**From:** Barbara Barhydt  
**To:** Dobson, Lannie  
**Date:** 7/30/2014 5:19 PM  
**Subject:** Fwd: Get Air Portland  
**Attachments:** 4-Traffic Report.pdf; A1 Floor Plan.pdf

>>> Benjamin Murray <bmurray@coffineng.com> Monday, July 28, 2014 1:40 PM >>>

I talked to Brian at Get Air about a couple of clarifications on the floor plan that you have for the project at 921 Riverside Street. I have also been in contact with Richard Nason at the State Fire Marshal's Office and he had a couple of the same questions. Please find below a listing of the answers:

FLOOR PLAN
SCALE 1/4" = 1'-0"

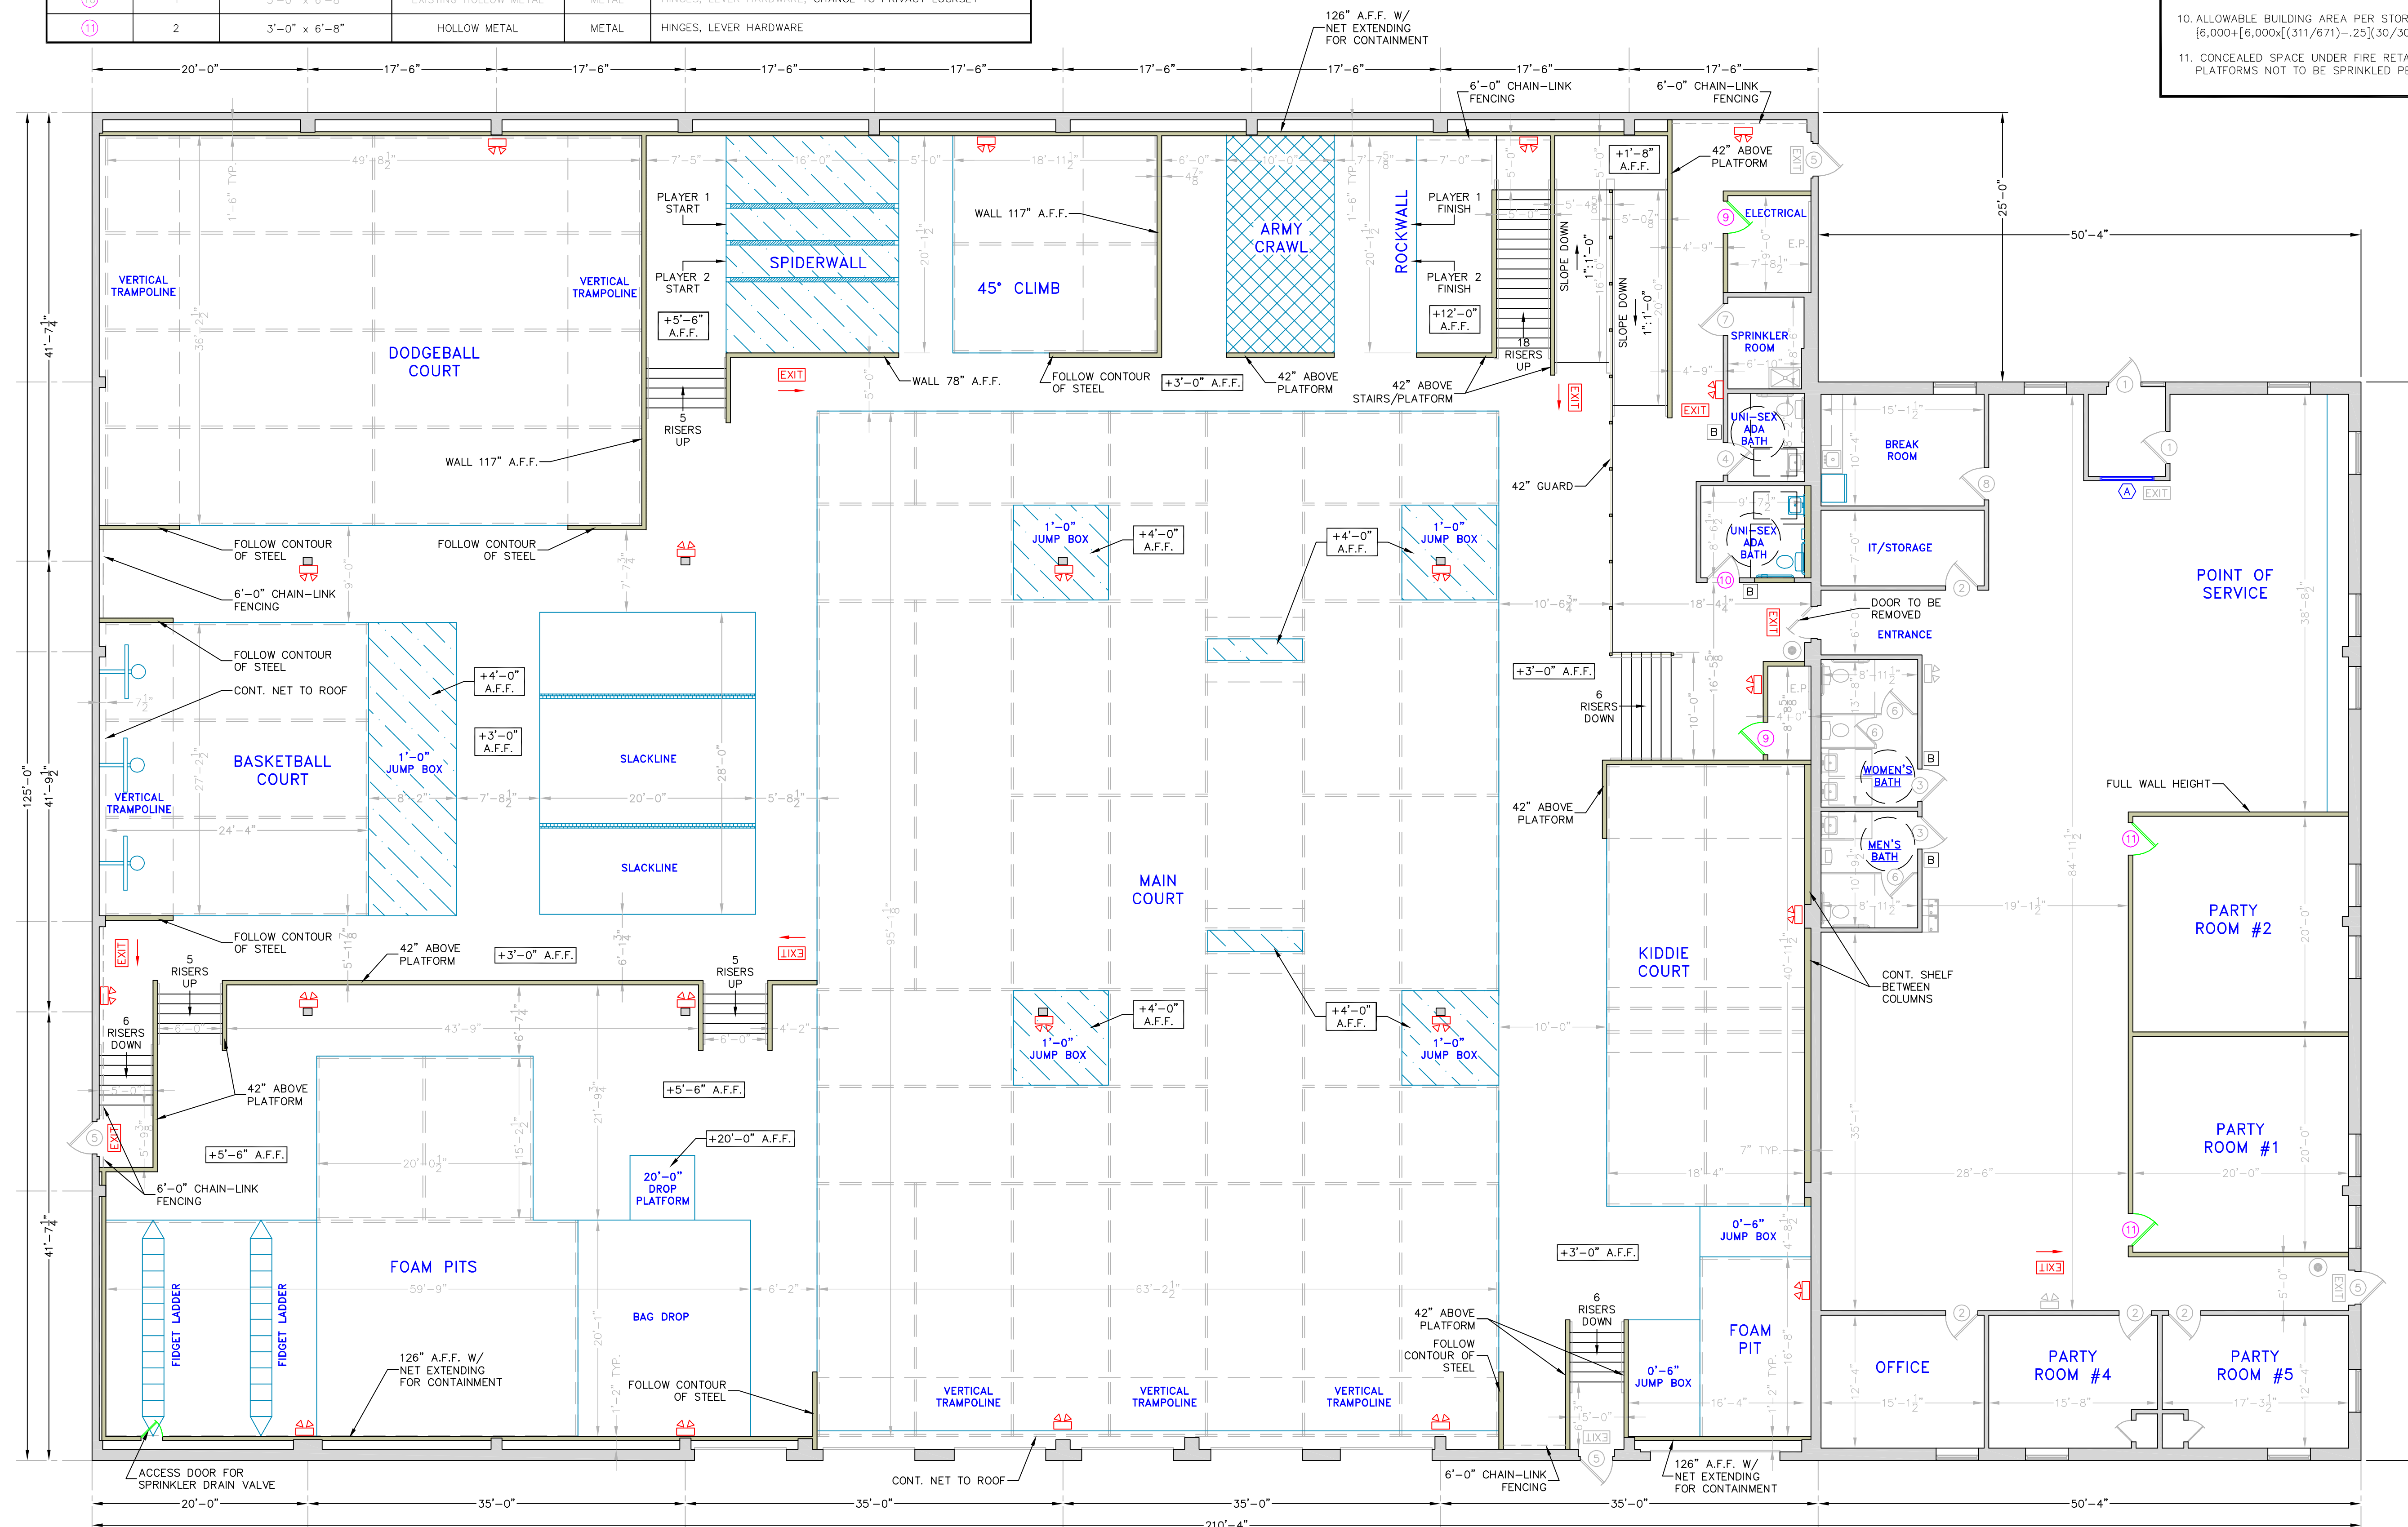
2. I have attached a revised floor plan that shows the maximum travel distances. The maximum distance I found is 169', which is below the 250' maximum.

3. The revised floor plan also shows the maximum occupant load for each of the Party Rooms at 27 people using 15 SF/person. Therefore, a second means of egress will not be required out of each room.

4. The obstacle course (Ninja Course) at the top of the page has four different obstacles that participants will go through. They start at one end and then race each other through the course ending up at the rock wall at the end. In between each obstacle, there will be a platform level with the common platform. I have labeled each of these areas as 3'-0" A.F.F. for clarification.
